Response to Planning application from Hertfordshire County Council (T and CP GDP Order 2015)

District ref: 6/2021/1430/ADV
HCC ref: WH/7211/2021
HCC received: 20 May 2021
Area manager: Matthew Armstrong
Case officer: Paul Marshall

THE BEACON MOSQUITO WAY HATFIELD AL10 9WN

Installation of internally illuminated wall-mounted fascia sign

Design Proposal: APC-JVF.01

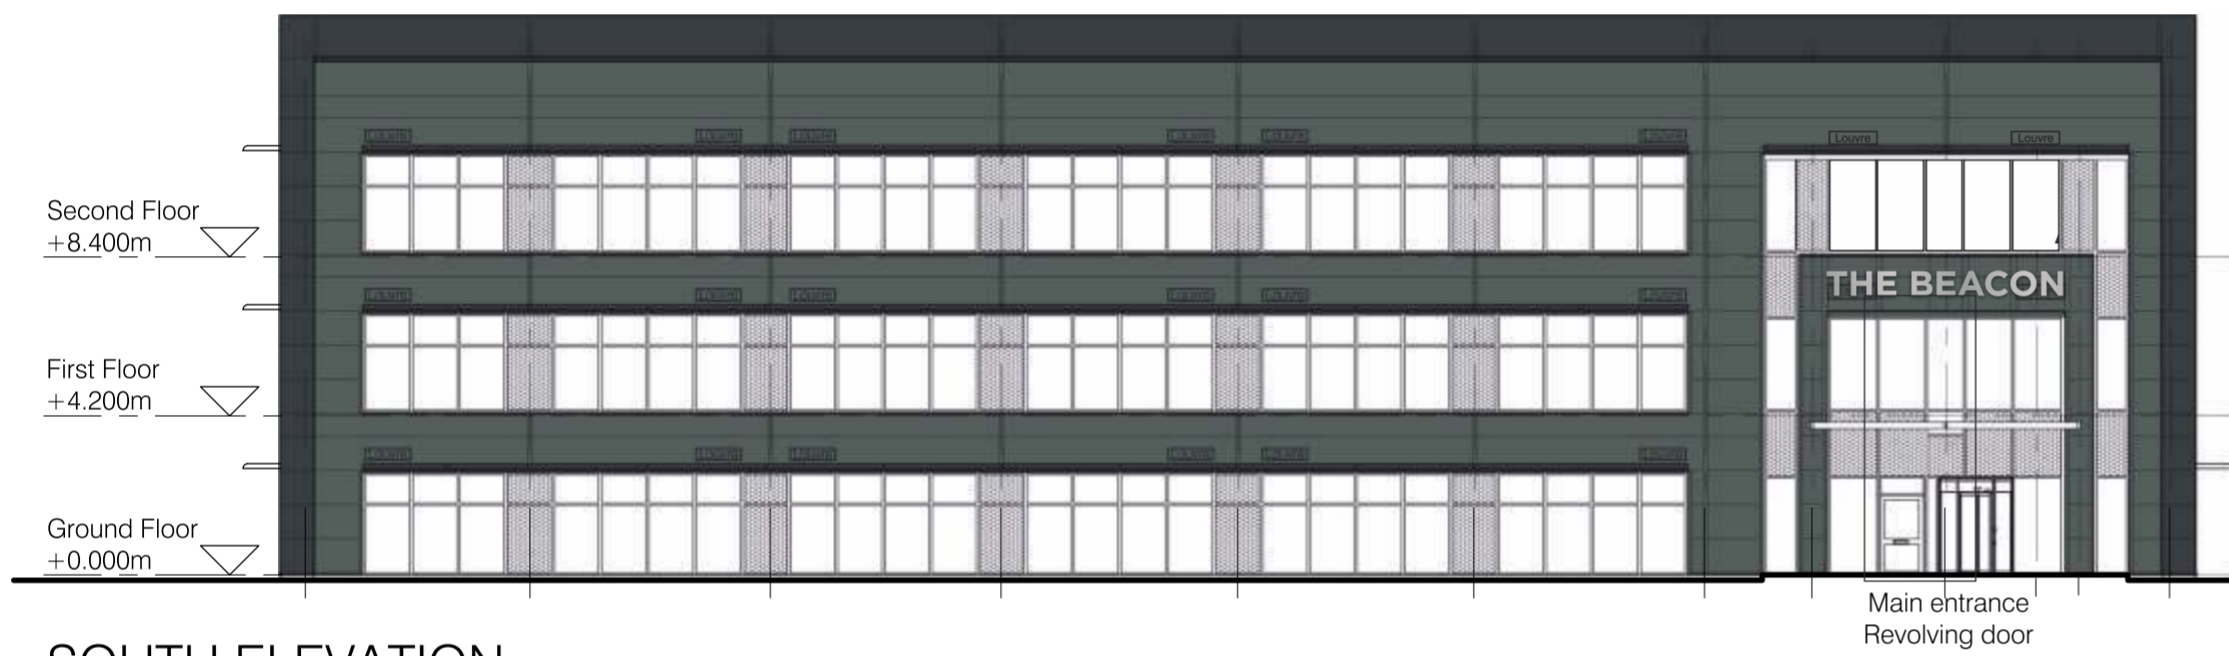
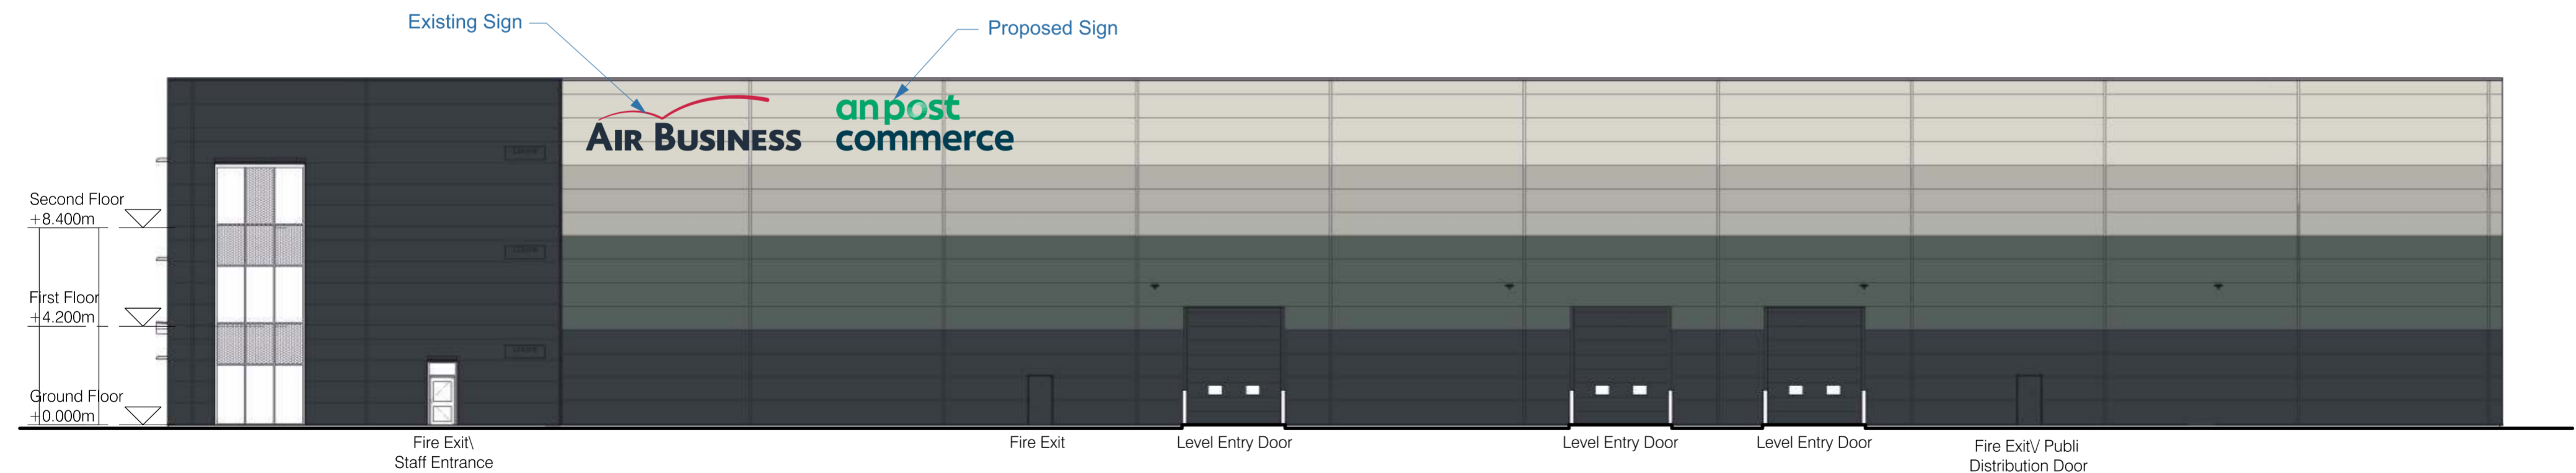
The position of the signage on the building (subject to the conditions) is unlikely to have any impact on road user intervisibility on Mosquito Way, nor would they represent an increase in signage contrary to MfS guidance, the highway authority therefore present no objection to the proposal.

Design Proposal: APC-JVF.03

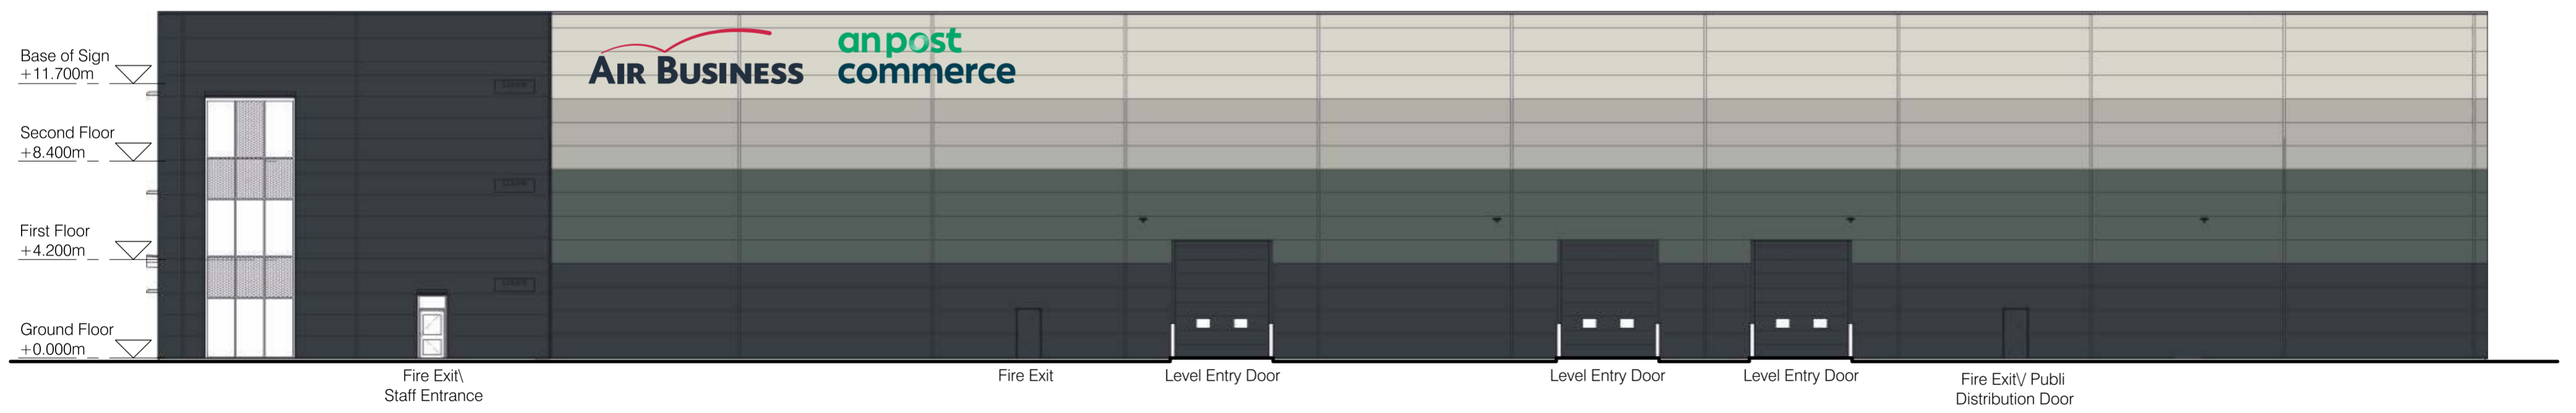
CON1) Prior to the first use of the development hereby permitted the intensity of illumination shall be controlled at a level that is within the limit recommended by the Institution of Lighting Professionals in the publication 'Technical Report No 5: Brightness of Illuminated Advertisements' and 'Guidance Notes for the Reduction of Obtrusive Light GN01:2011'.
